KITTITAS COUNTY DEPARTMENT OF PUBLIC WORKS

MEMORANDUM

TO: Noah Goodrich, Staff Planner, Community Development Services
FROM: Randy Carbary, Planner II
DATE: August 25, 2006
SUBJECT: Koren Short Plat

KOREN SHORT PLAT
PART OF SECTIONS 8 AND 9, T. 19 N., R. 15 E., W.M.
KITITAS COUNTY, WASHINGTON

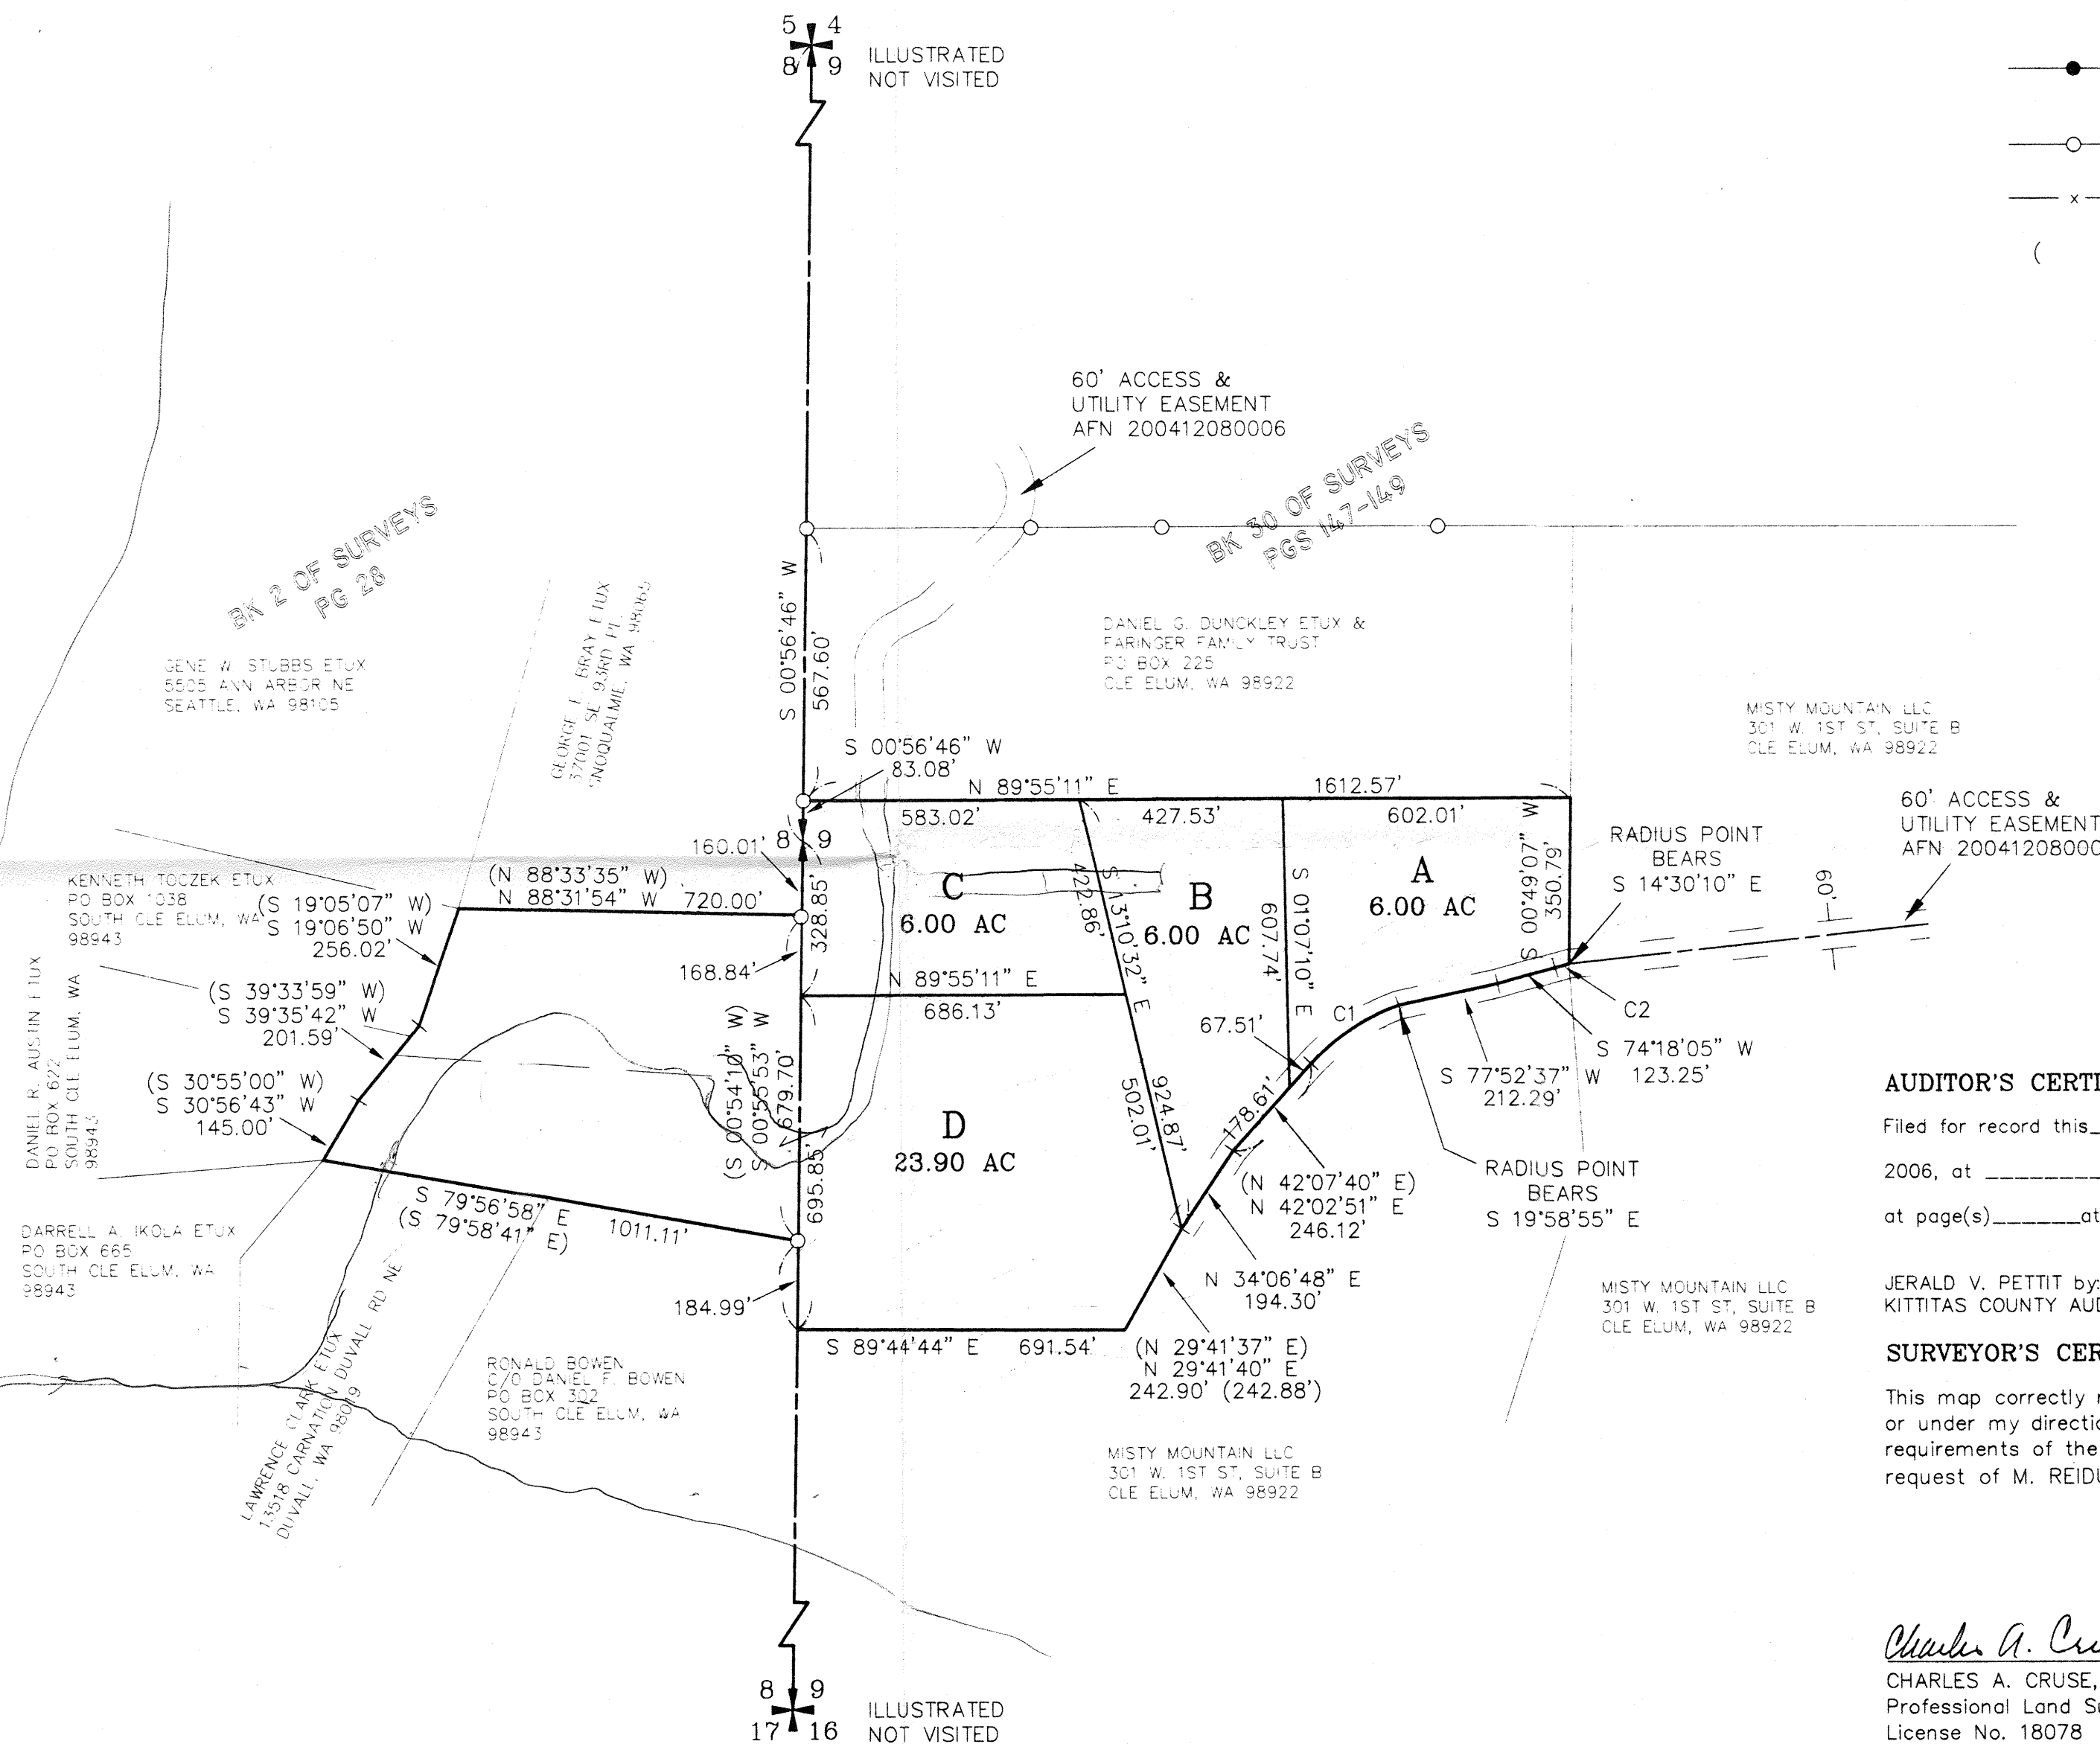
1. Access Easement for Lot A & B: Access for Lots A & B shall be via the 60' access easement, AFN 20041208006, as shown on the face of the preliminary plat. Lot B may also be accessed from the west via the 40' access easement, as shown on the face of the preliminary plat.

2. Joint-Use Driveway – Access Easement for Lot C & D: Access for Lots C & D shall be via the 40' access easement, as shown on the face of the plat. Lot B may also be accessed via the 40' access easement, as shown on the face of the preliminary plat. Access shall be constructed to serve no more than two parcels. (See current Kittitas County Road Standards)

- a. Access Easements shall be improved to a minimum of 20'. The roadway width shall be 12', gravel surface. (The 40' access easement, as shown on the face of the plat is acceptable).

3. Requirements for Roads within the 60' access easement, AFN 20041208006: Other properties and proposed developments, in the area, access their property via the 60' access easement, AFN 20041208006, as shown on the face of the preliminary plat. As a result, road improvements are required. These roads appear to serve the Koren Short Plat, as well. Lots A & B are served directly by a road from the east, yet to named. While Lot C & D appear to be accessed via a joint use driveway within the 40' access easement, as shown on the face of the preliminary plat. Since these lots are all initially served via the 60' access easement, AFN 20041208006, a Private Road Certification of these main roads, within the 60' access easement AFN 20041208006, shall be required prior to the issuance of a Building Permit for any of the lots within the Koren Short Plat.

In addition, a Road Maintenance Agreement(s) between property owners served by these roads (directly or indirectly) shall be required.
